EPC STORMWATER REVIEW COMMENTS
IN ORANGE BOXES WITH BLACK TEXT

~~Master Development Drainage Plan and
Final Drainage Report~~

Peerless Farms
16975 Falcon Hwy
Peyton, CO 80831

Prepared: June 26, 2024

DATE APPROVED: 12/31/05	Rural Local Roadway	
APPROVED: John A. McCarty	REVISION DATE: 12/22/05	FILE NAME: SD_2-11
DEPARTMENT OF TRANSPORTATION

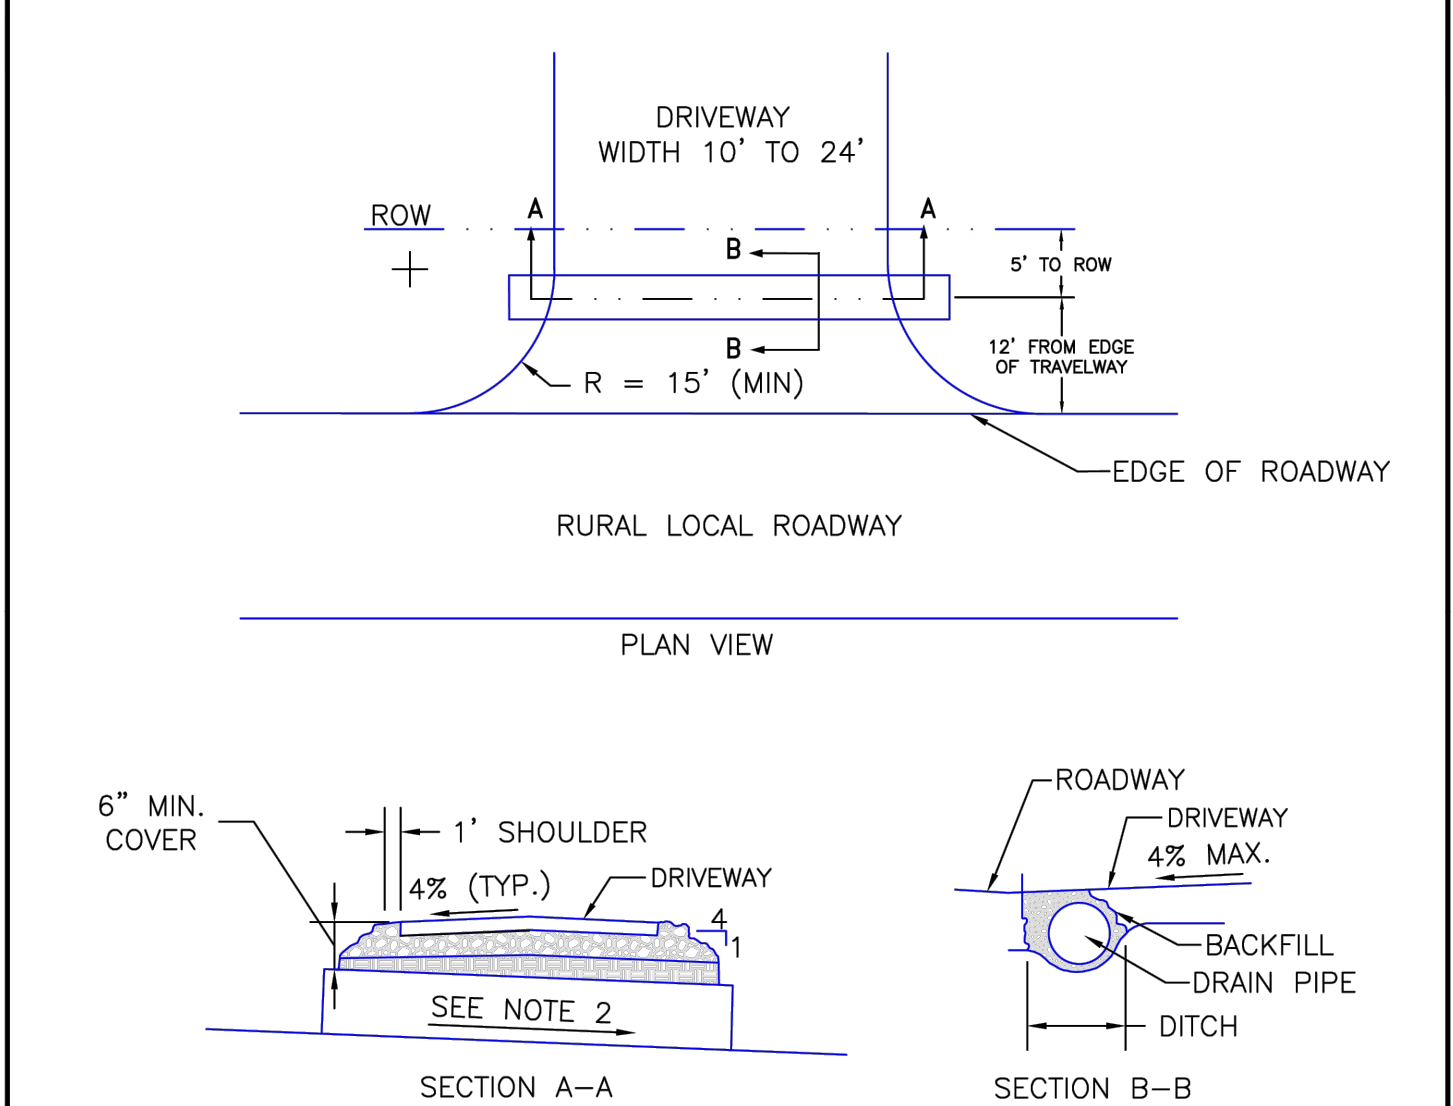
Unresolved:
Per ECM section 3.3.4.B.1 minimum ditch slope is 2.0% or min velocity of 6 fps. This criteria is for "right of way" ditches, which are roadside ditches.

Unresolved:
Per ECM section 3.3.4.B.2, ditch should have freeboard of 0.5'. This criteria is for "right of way" ditches, which are roadside ditches.
